Application by Awel y Môr Offshore Wind Farm Limited for an Order Granting Development Consent for the Awel y Môr Offshore Wind Farm project

The Examining Authority's written questions and requests for information (ExQ1) Issued on 27 September 2022

Drawing file: EN010112 / EN010112-001327-6.22_D6_AyM_Statutory_Non_Statutory_Nature_Conservation_Sites_Plan_RevD.pdf

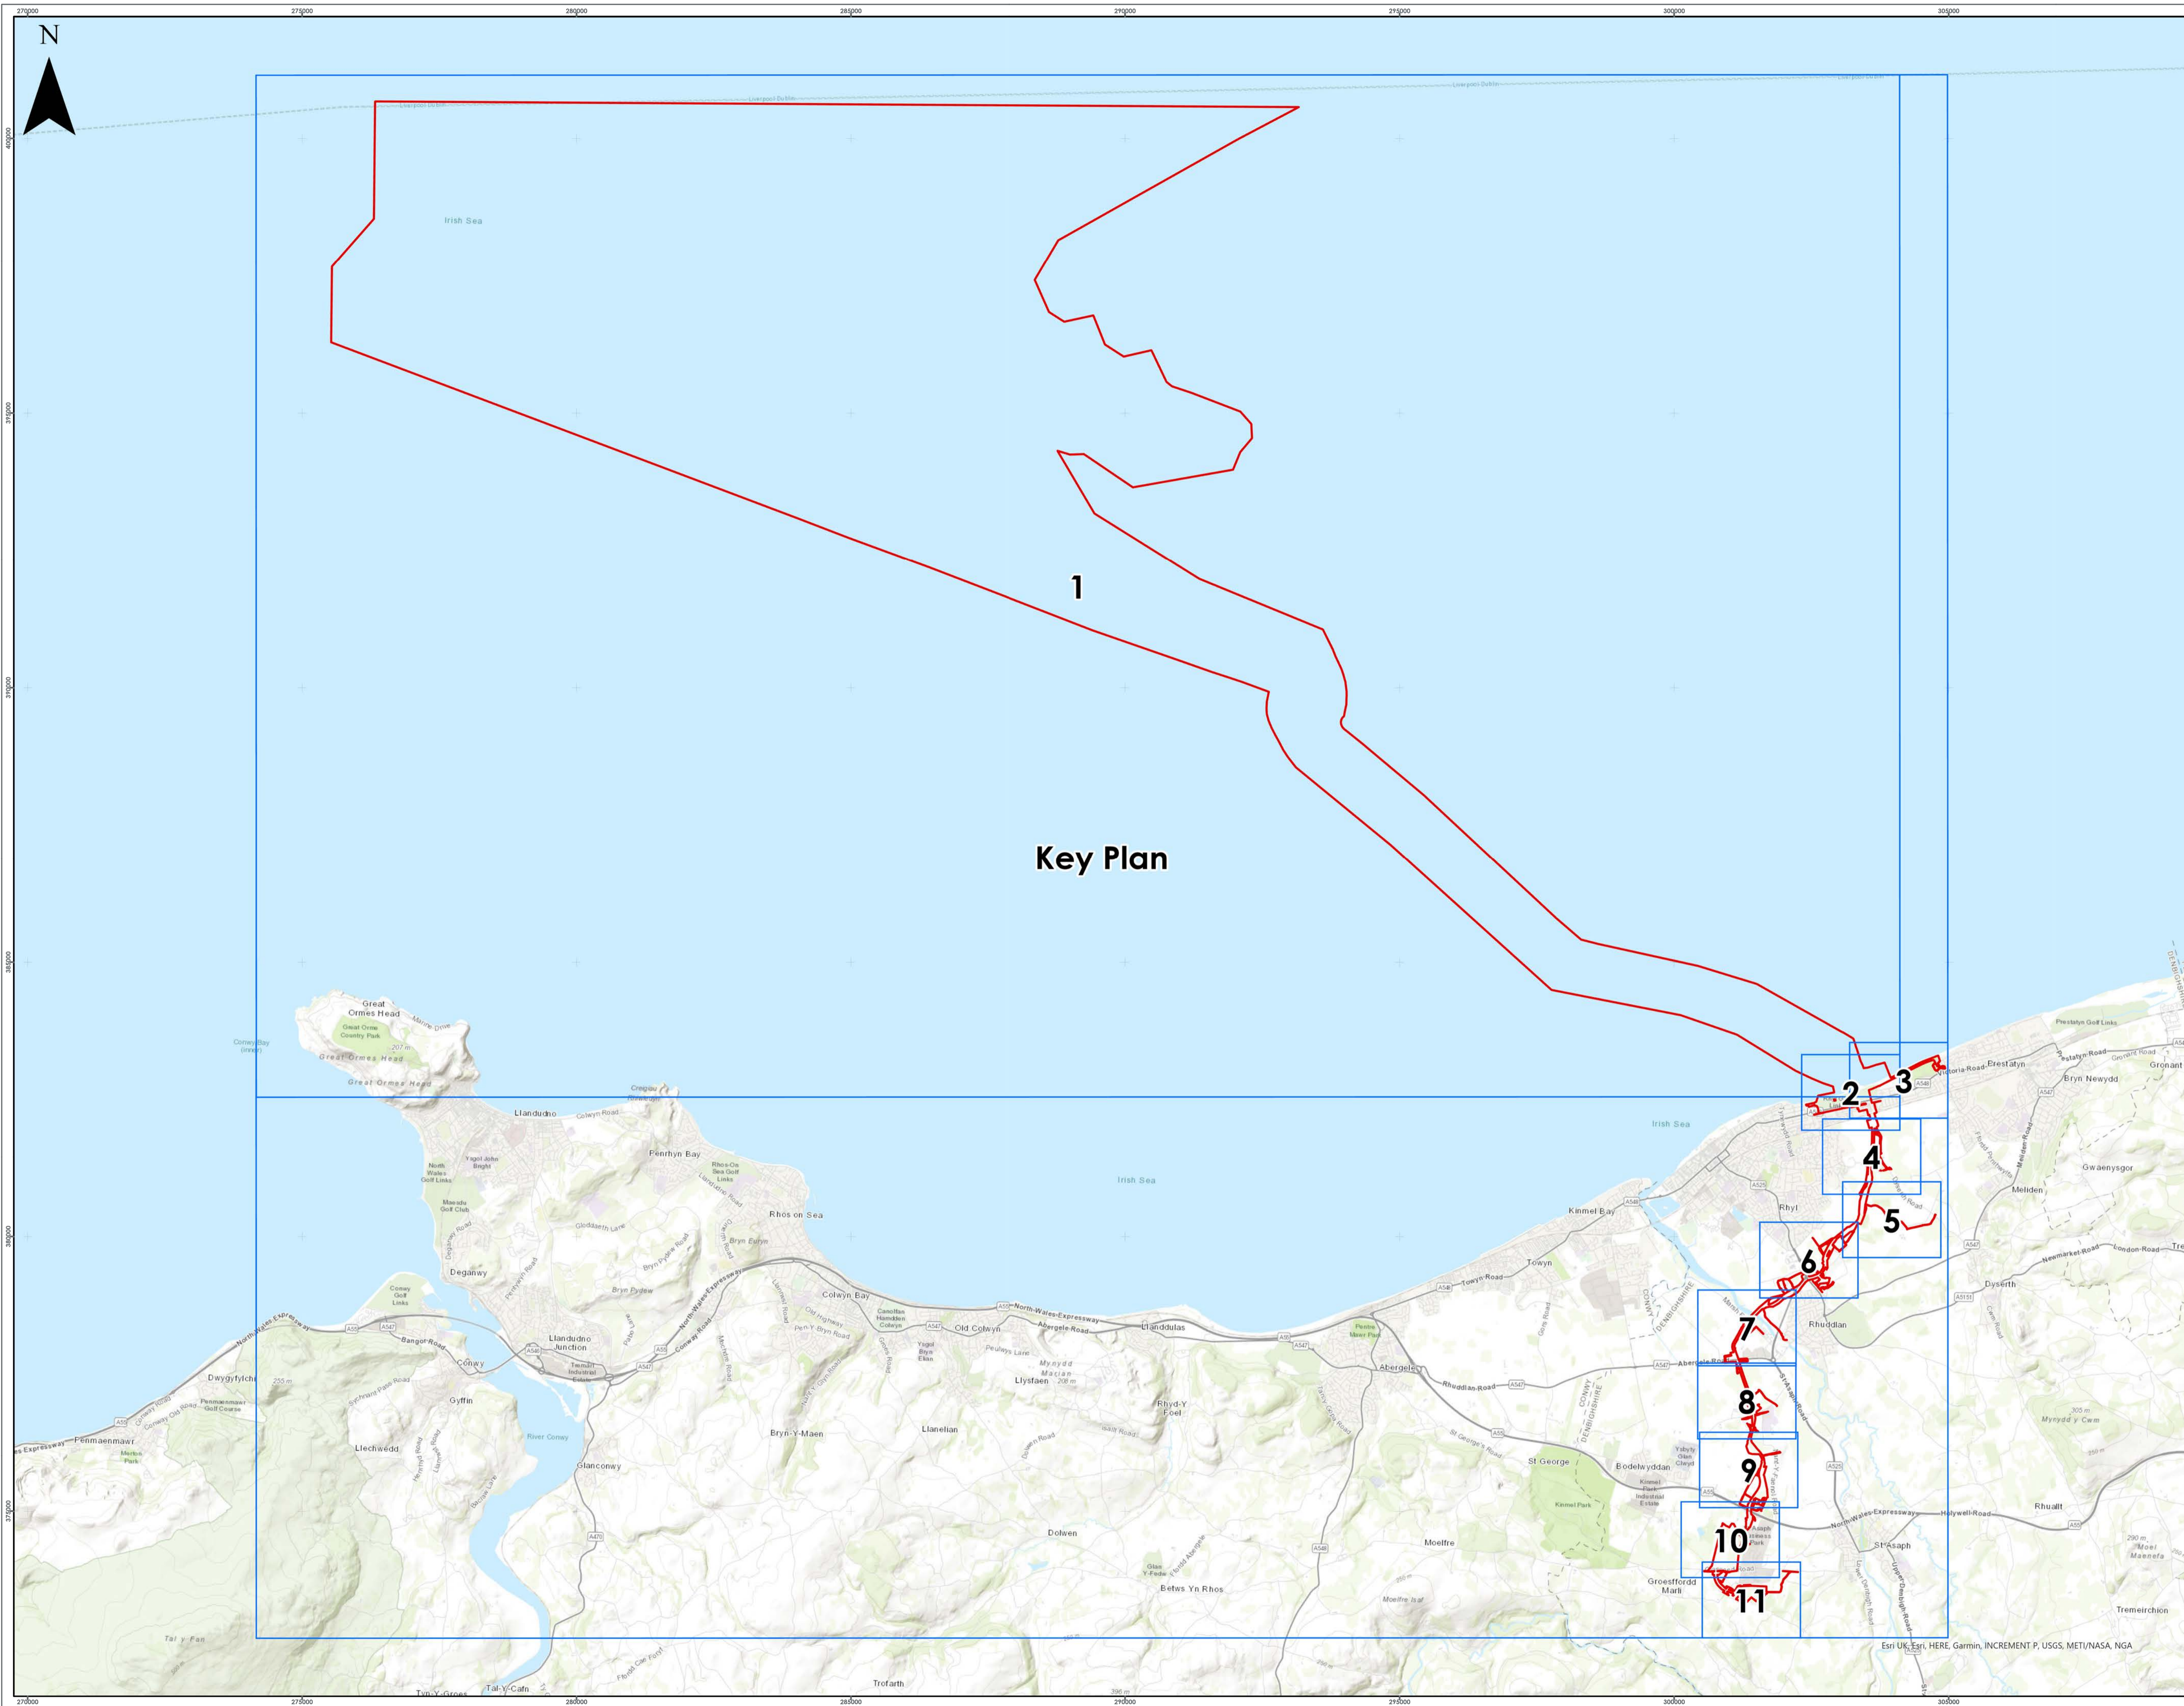
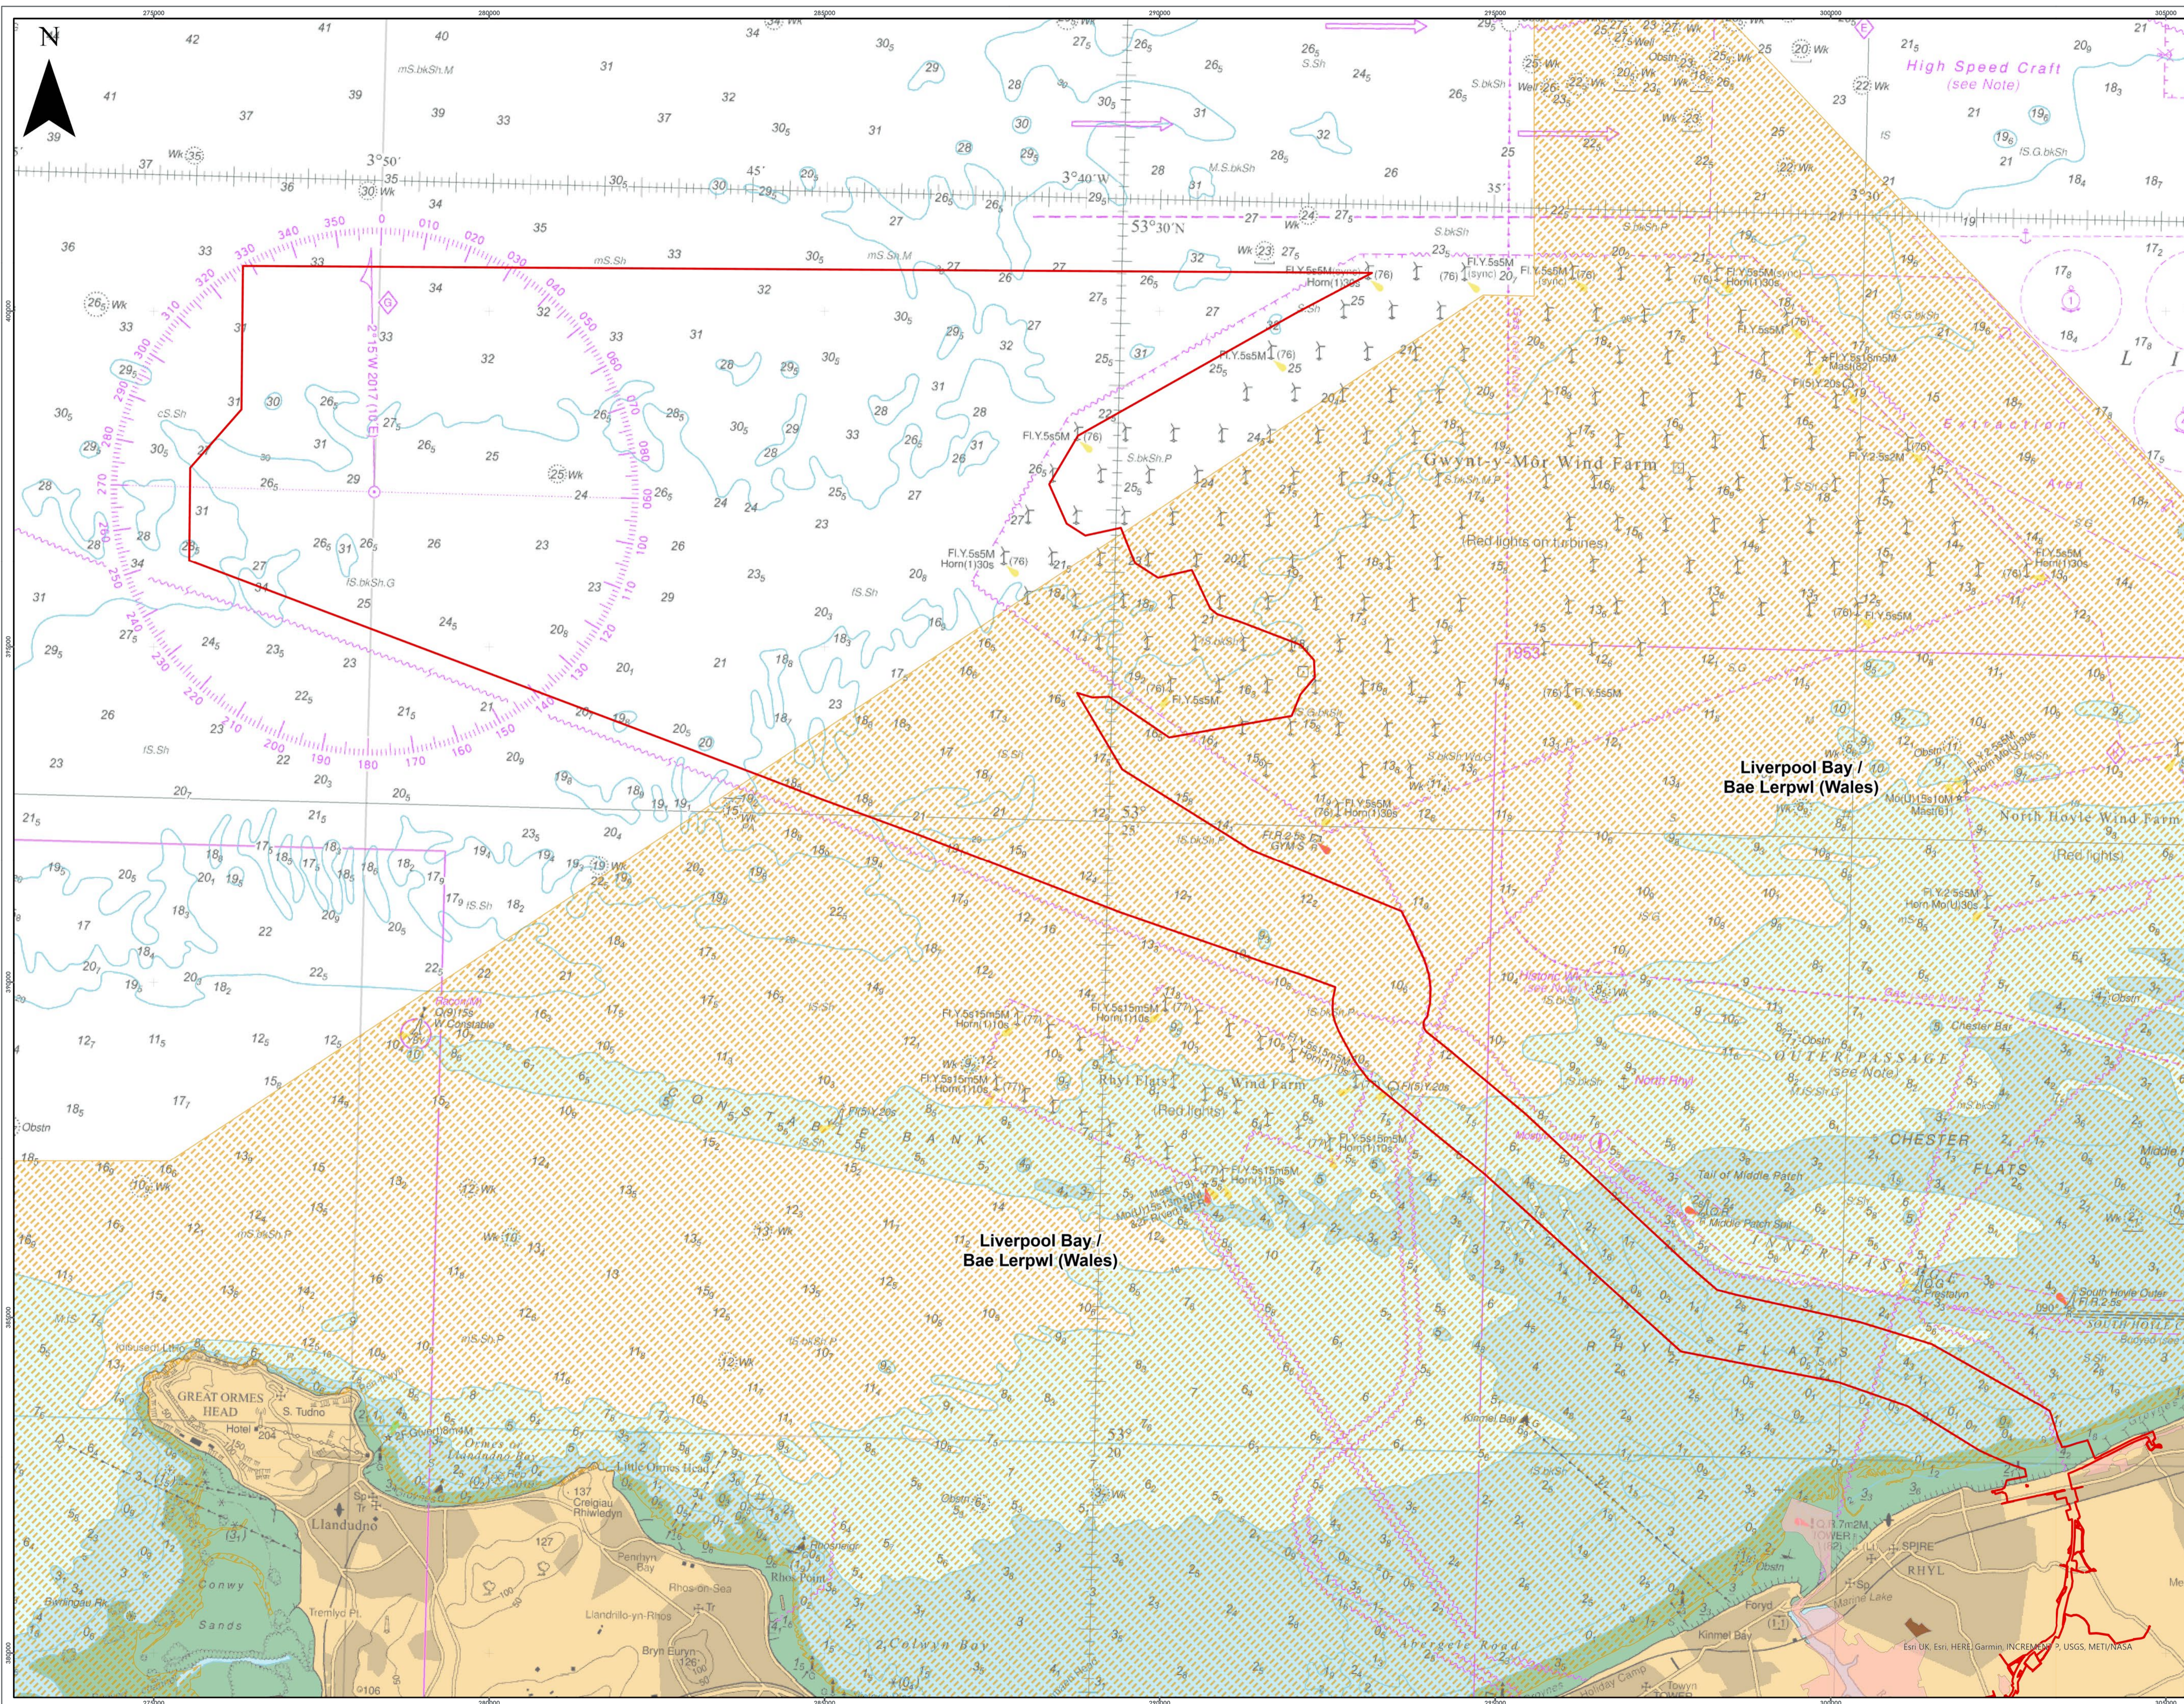
2.7	The Applicant	<p>General Statutory / Non-statutory Nature Conservation Sites Plan [AS-010] Please can you address the following points:</p> <ul style="list-style-type: none">a) Sheet 1 of 11 - The legend does not reflect all hatch colours shown and the extents of SPA hatch appears to be different on sheets 2 and 3;b) Sheet 2 of 11 –does the drawn shape and extent of Local Wildlife Sites at western edge reflects y Ffrith D011;c) differentiate the woodland area to help identify other ancient semi-natural woodland, plantation on ancient woodland site and local other woodland;d) label the name of the other nature reserves on the relevant sheet.
